Orsted Onshore Ireland Midco Limited

2: MEMORANDUM RESPONSE TO SUBMISSIONS RECEIVED

Proposed Oatfield Wind Farm Project, Co. Clare: ABP
Case No. ABP-318782-24

Figure 6.10 Map of receptors within 2 km of the Proposed Development

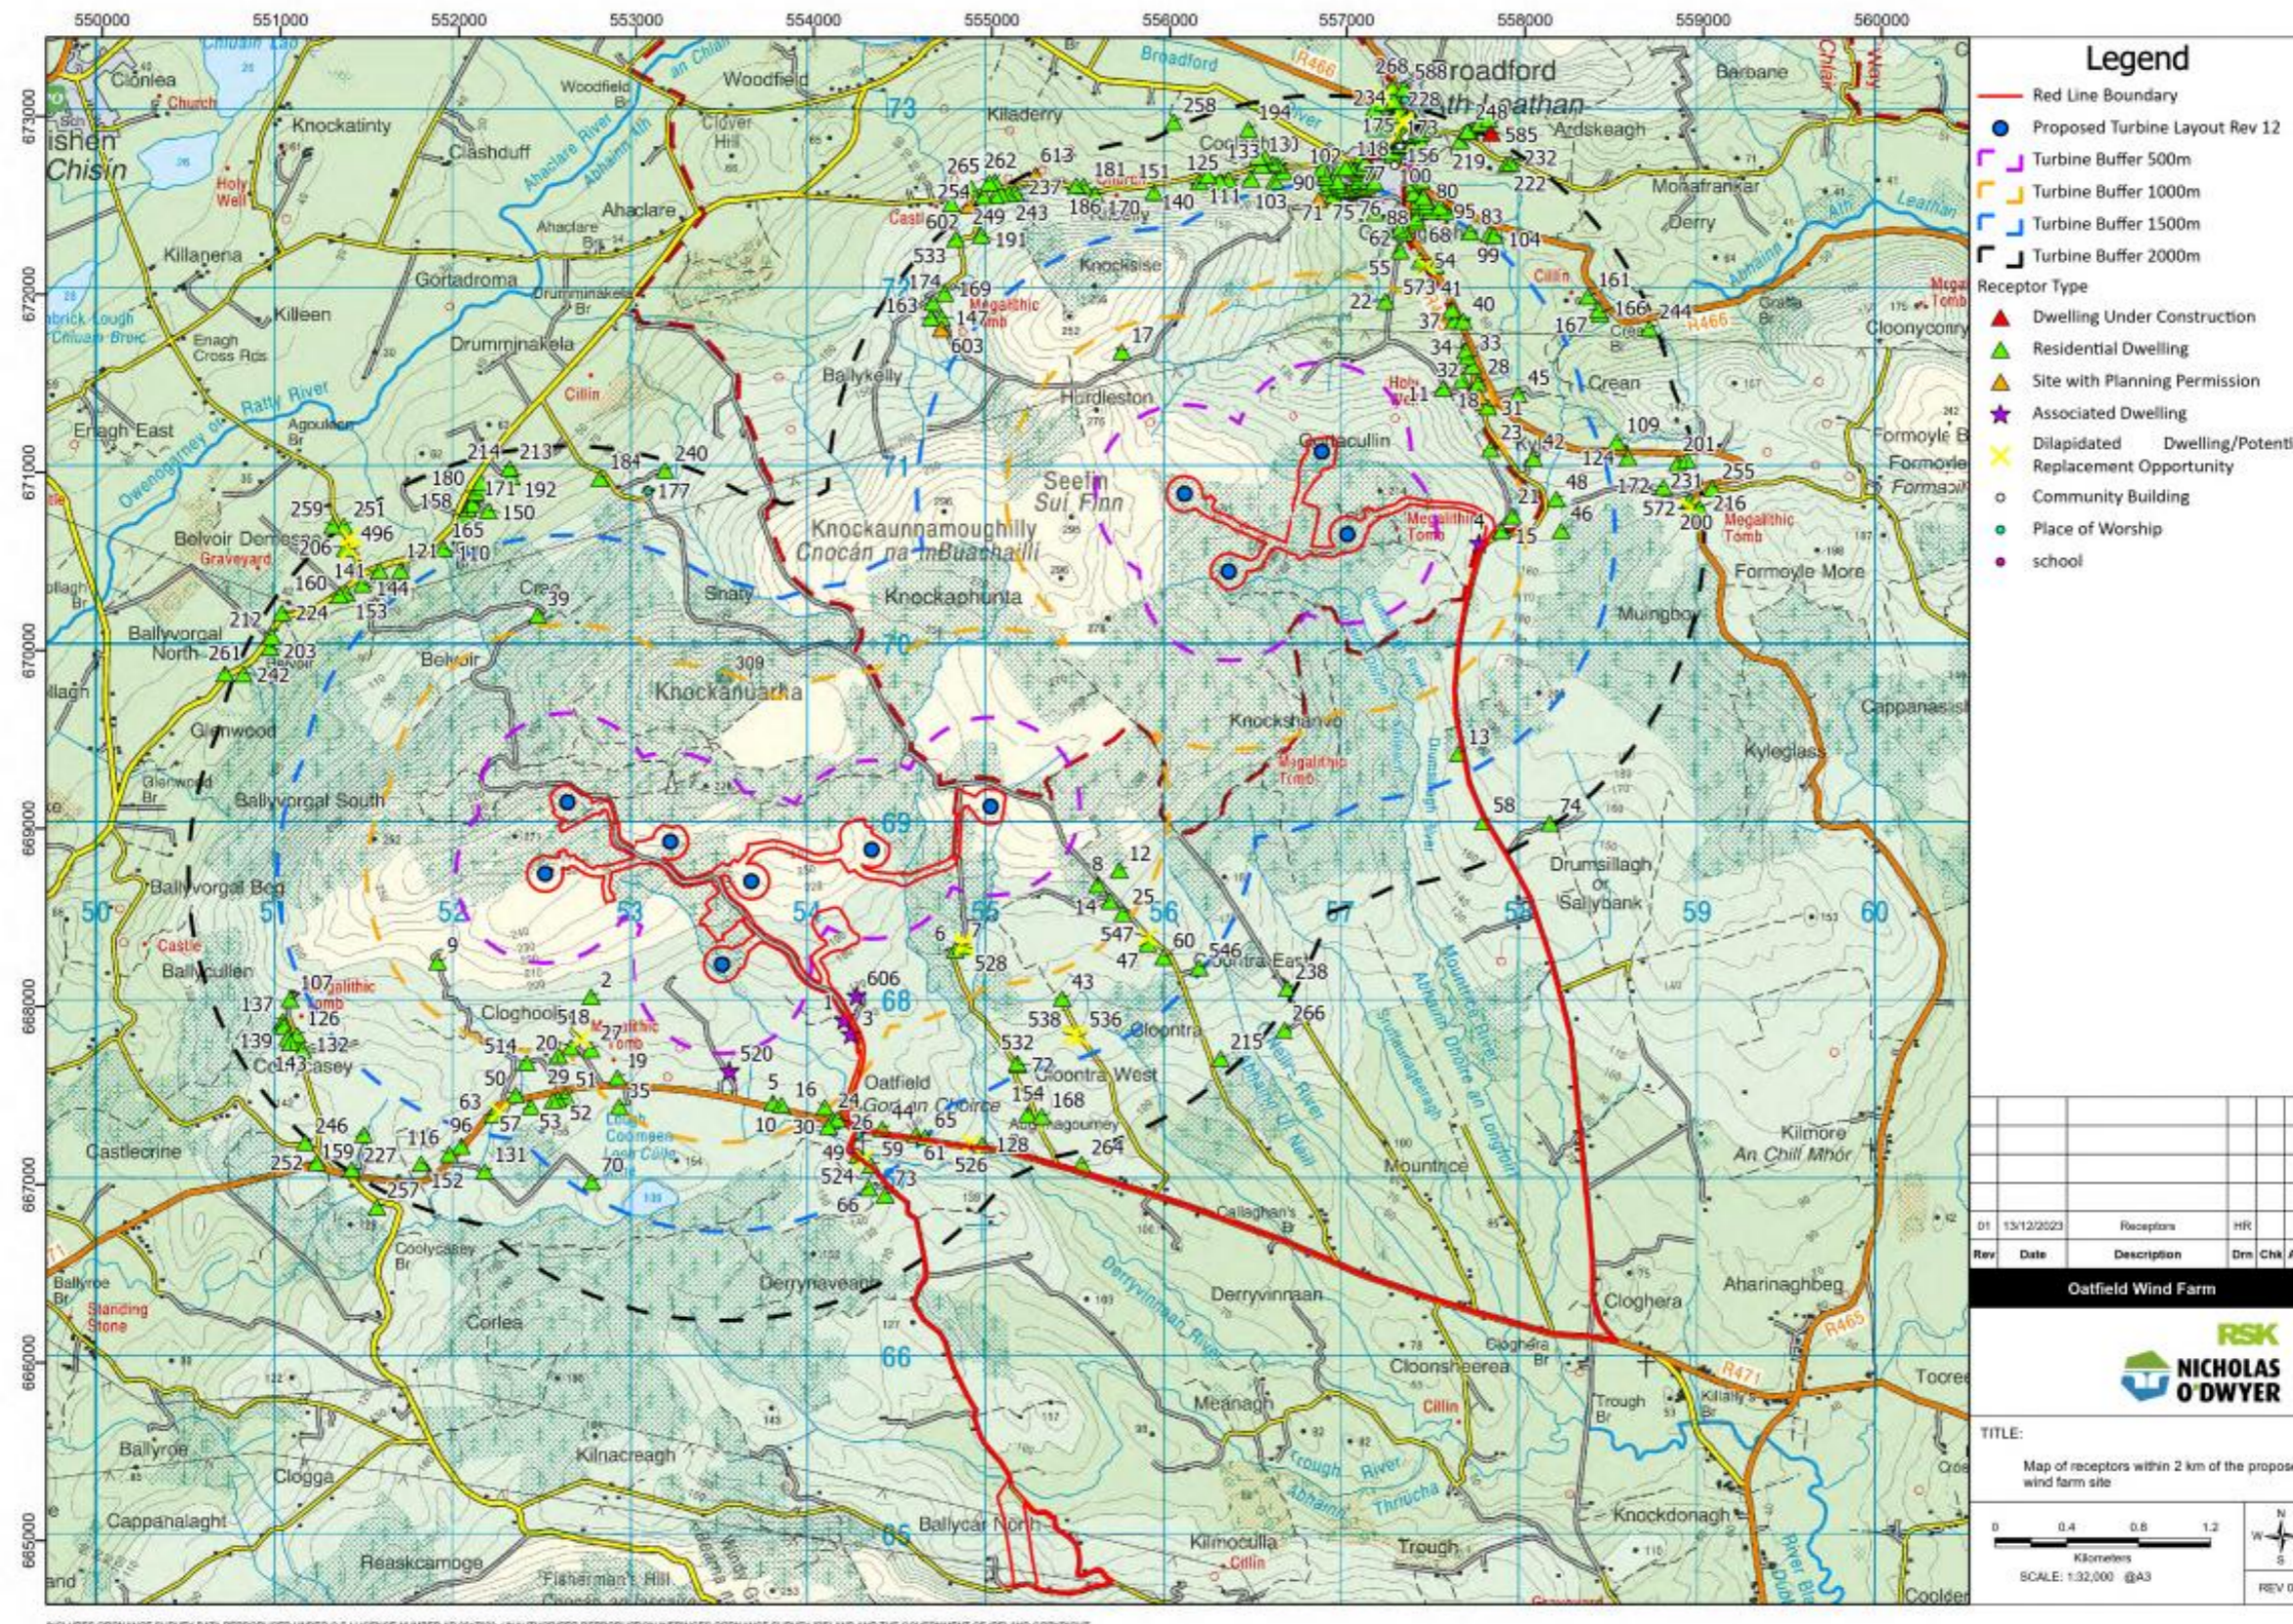
As noted in Section 4.6.1 of the Planning and Miscellaneous matters response (see Memorandum no. 1 in the response to submissions documentation), the Population and Human Health EIAR Chapter (**EIAR Chapter 6**) which was submitted as part of the original planning application contained an error in the naming of 'involved landowners'.

Figure 6.10 of **EIAR Chapter 6** identified receptor number 4 and 606 as 'involved'. It should be noted that receptor number 4 and 606 are not involved with the Proposed Development. An updated figure is provided below.
